2024/0859

Address: 100 Barnsley Road, Darton, Barnsley, S75 5NS

Description: Single storey rear extension (rendered), loft conversion to provide habitable area, installation of brick cladding, re-roof, install of 4 x front rooflights, tiles on front bay windows and new rear dormer, to single storey dwelling (amended description).

TITLE
LOFT CONVERSION
PROPOSED ELEVATIONS

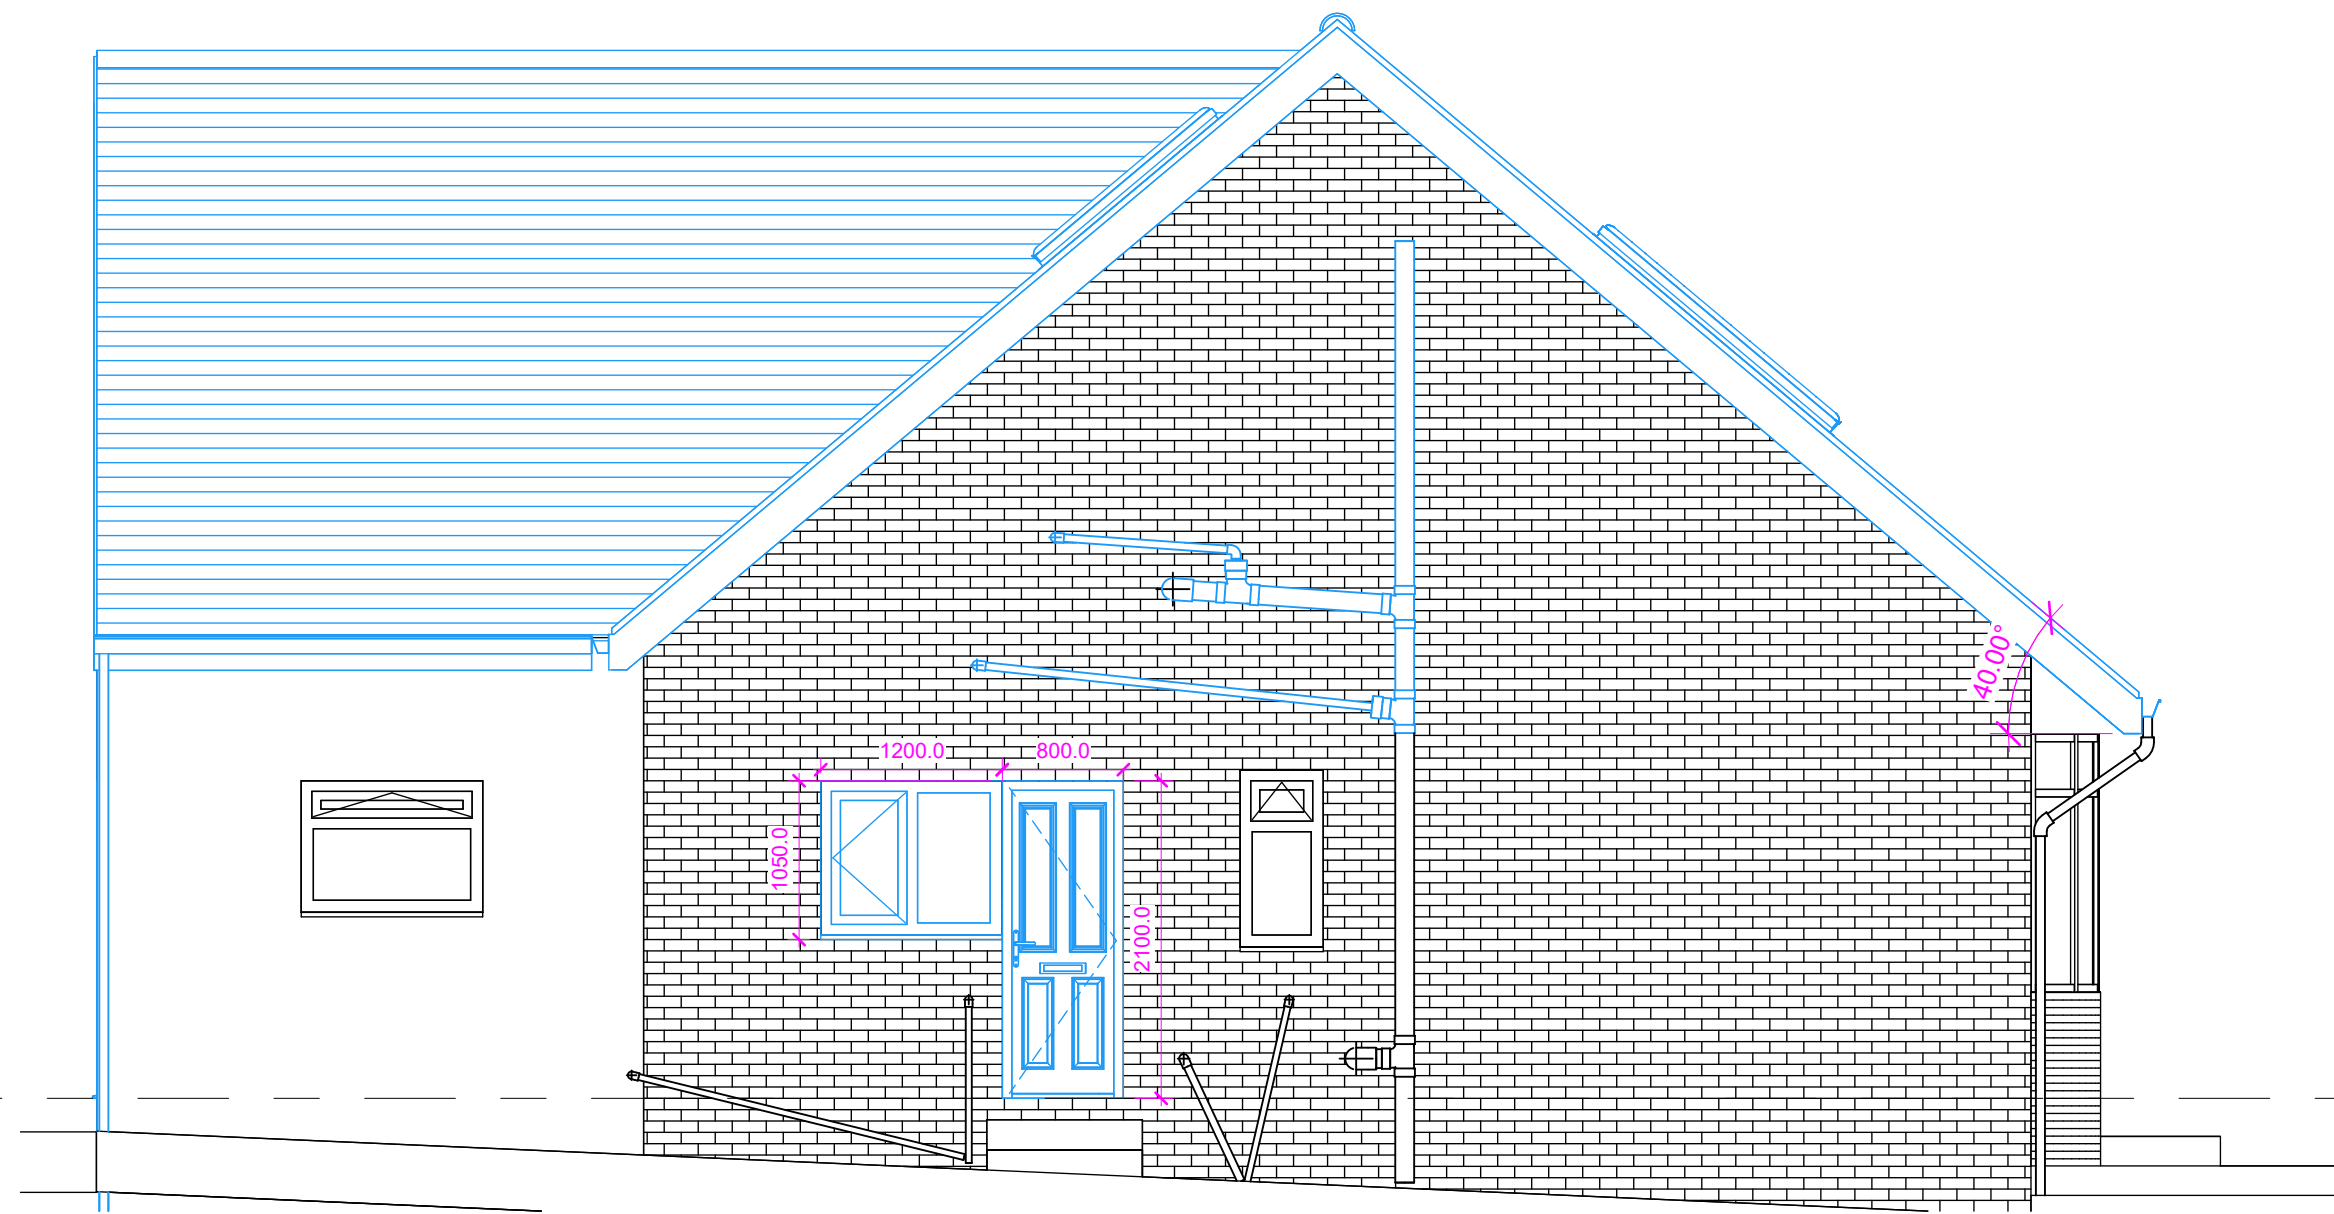
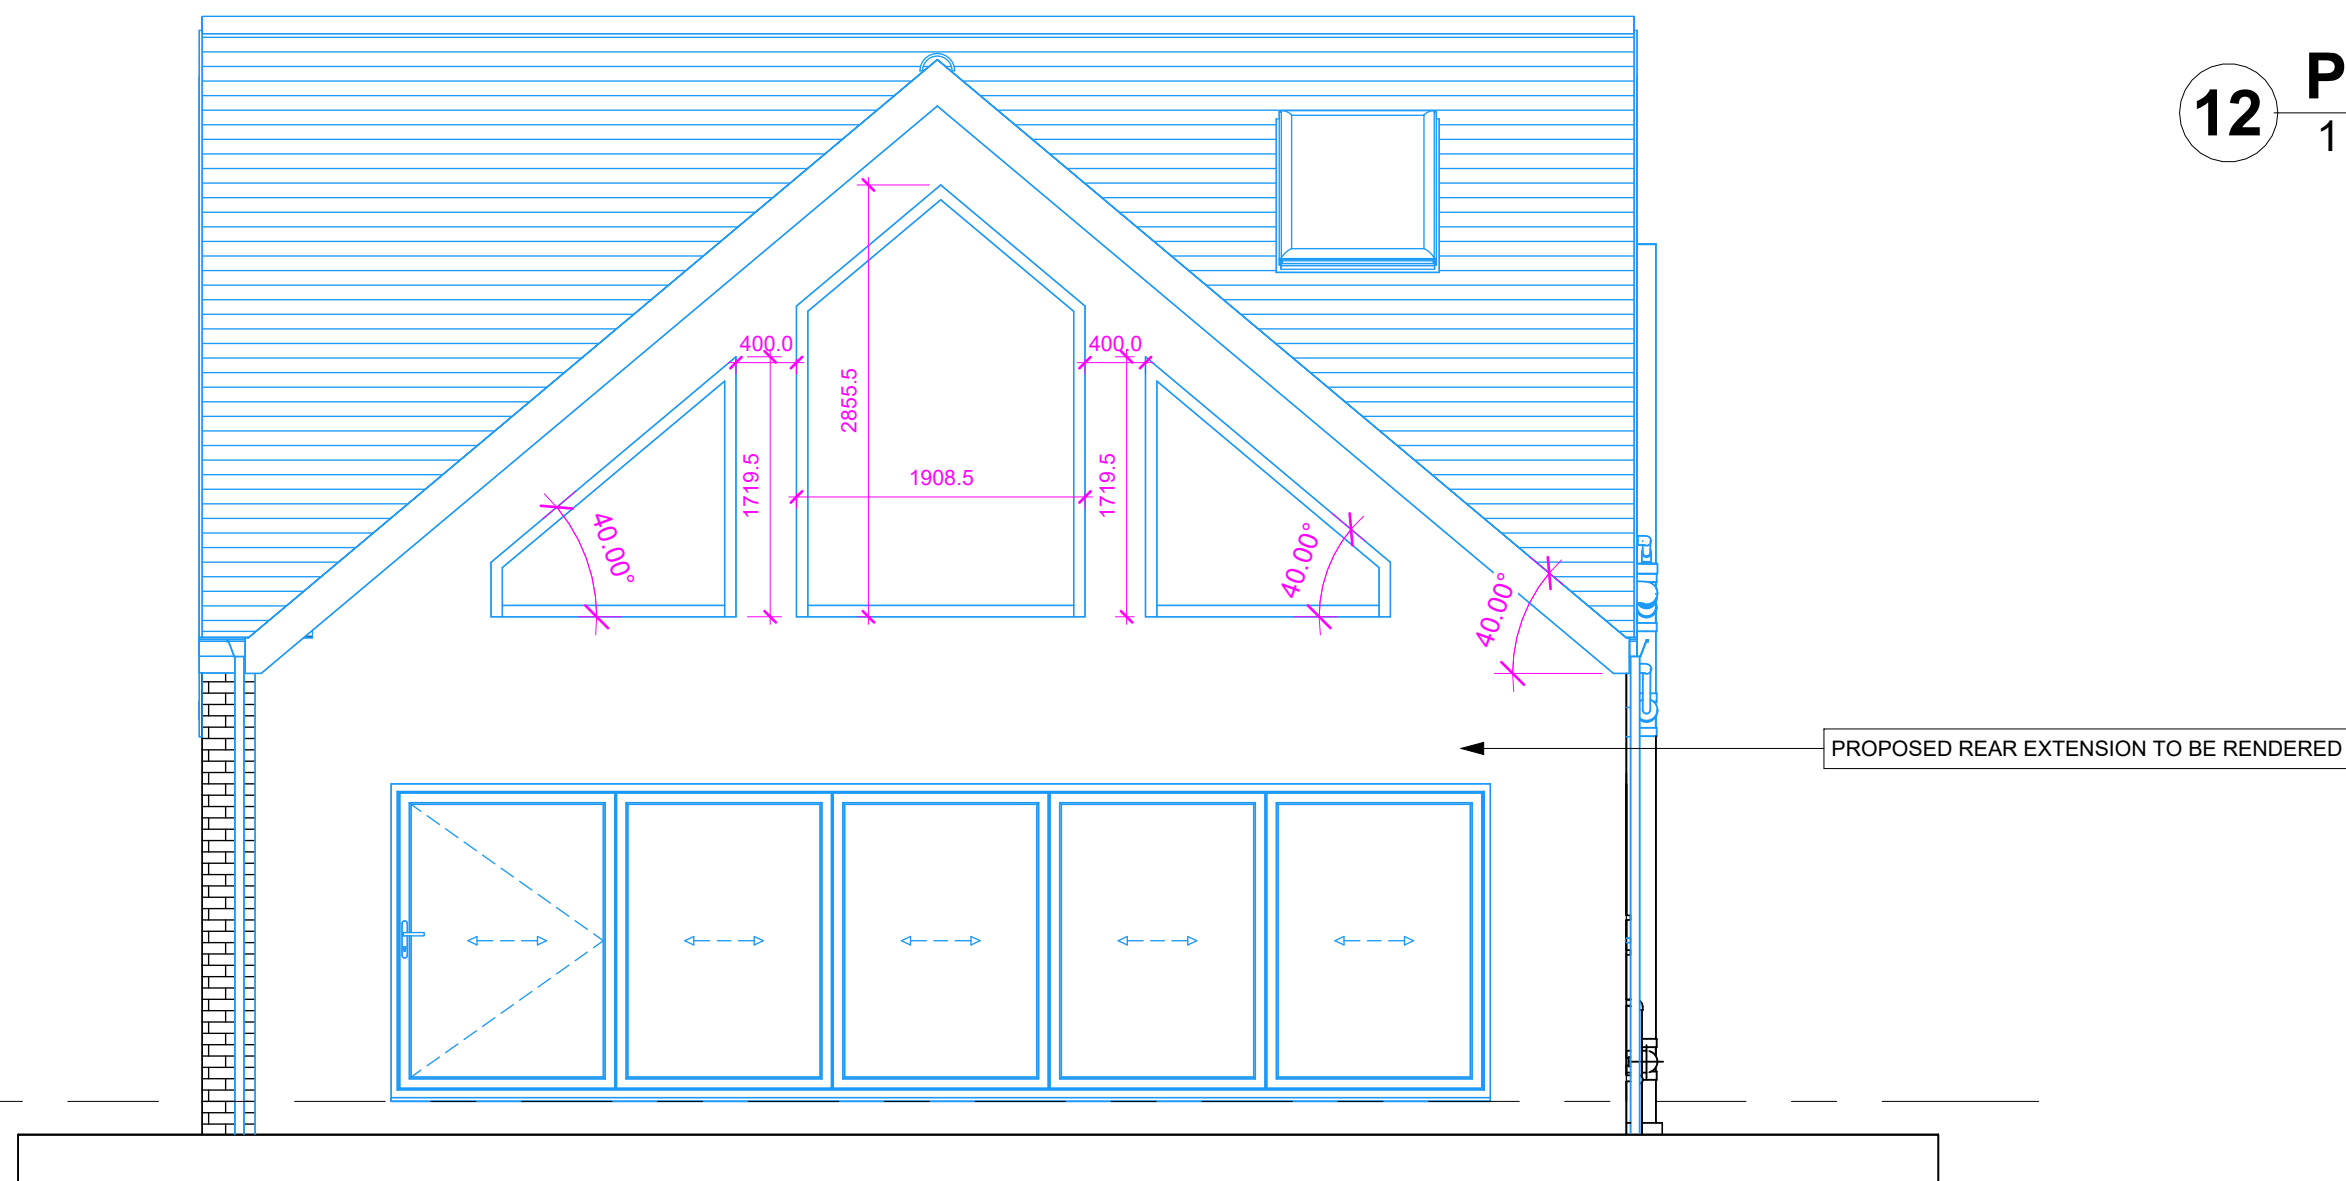
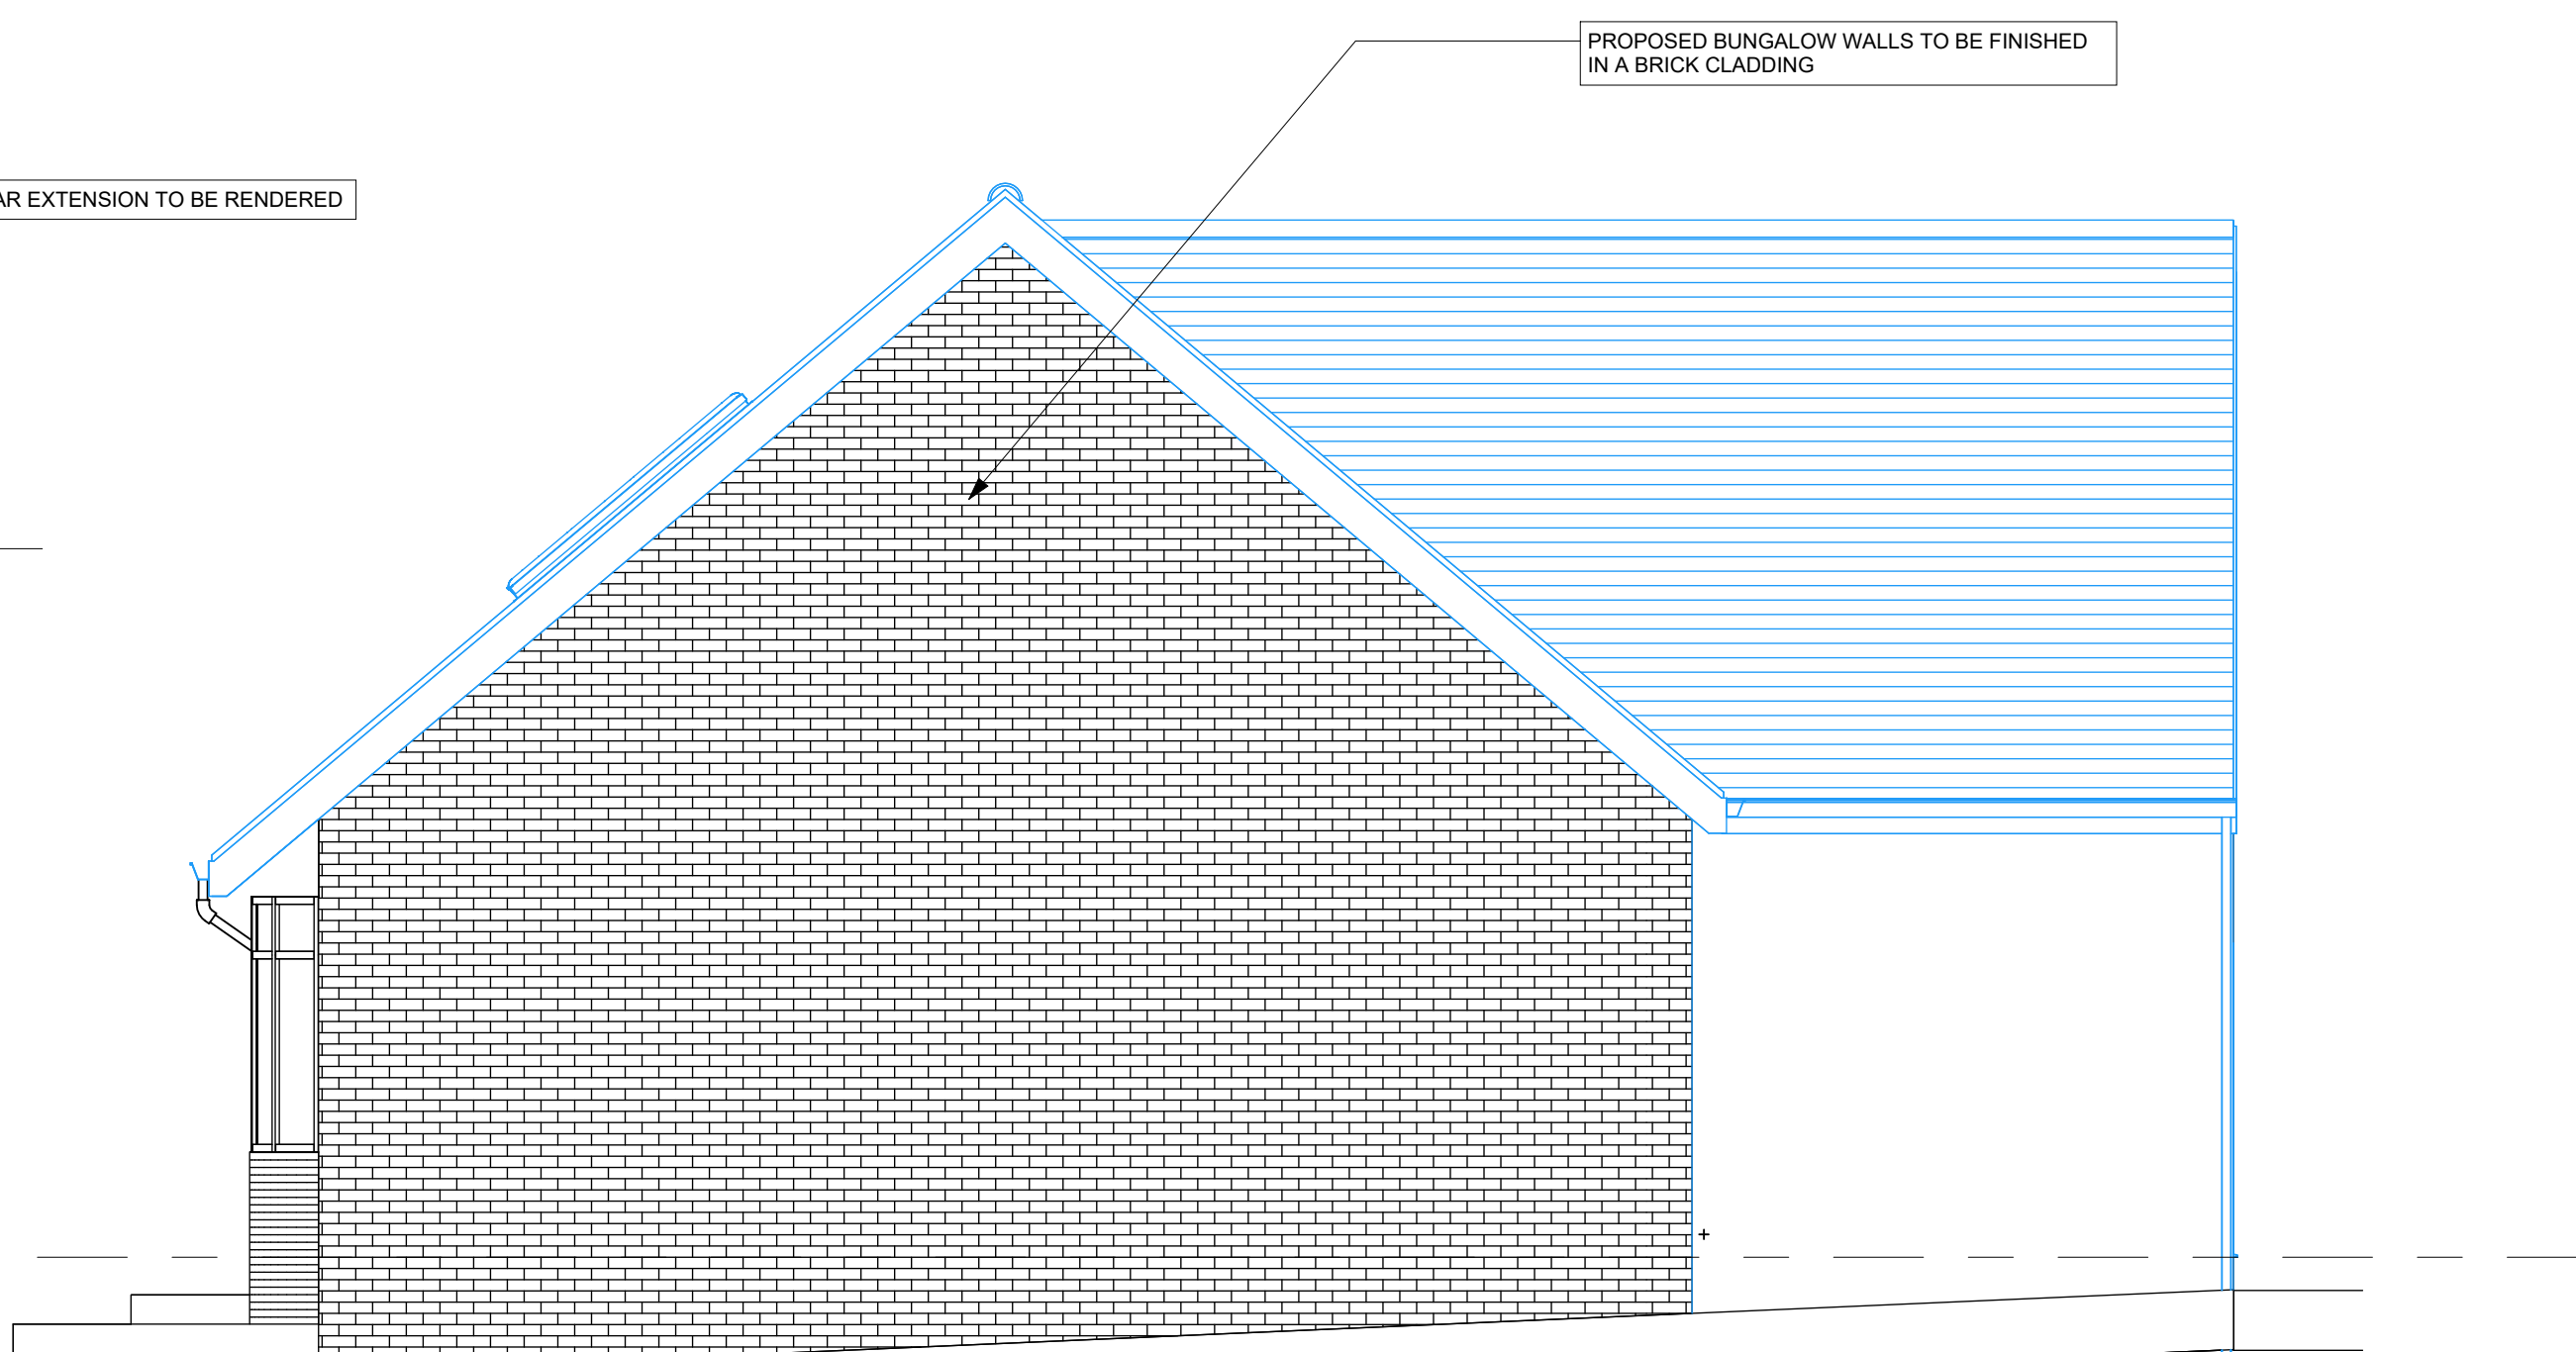
In addition to a neighbour objection about the amount of render proposed for the dwelling, the limited render on the original dwelling and lack of fully rendered dwellings within the nearby street scene, revised plans were requested and subsequently submitted. The new plans limit the proposed areas to be rendered to the extended or replaced rear extension and the rear elevation of the dwelling. In lieu of rendering, new brick style cladding would be used for the remaining walls of the bungalow. An image of the proposed cladding was provided and whilst the cladding would be a slightly lighter brick color than the original, it provides the appearance of brick, which would match with the various styles and materials used within dwellings within the street scene. The currently rendered sections below the front bay windows would be tiled in matching tiles to the proposed roof.

Original plans included dormer windows on the front elevation but these are not a characteristic of the street scene. Following a request, revised plans were submitted that removed the front dormer windows and included four Velux style roof light windows on the front elevation. In contrast to the other works, the proposed roof lights would have minimal impact on the character of the dwelling, and would have significantly less impact upon the street scene compared to the originally proposed dormers. There would be some differential in character of the renovated bungalow to that of the original dwelling but many dwellings within the street scene are unique in their design, with even the neighbouring bungalow of a different design to the application bungalow. Therefore, the refreshed dwelling would sit well within the street scene, despite the height differences which already and would continue to exist. In the new street scene, the neighbouring two-story dwelling would feature a less prominent height difference to the application dwelling, with the application dwelling acting as an intermediate step down to the adjacent bungalow.
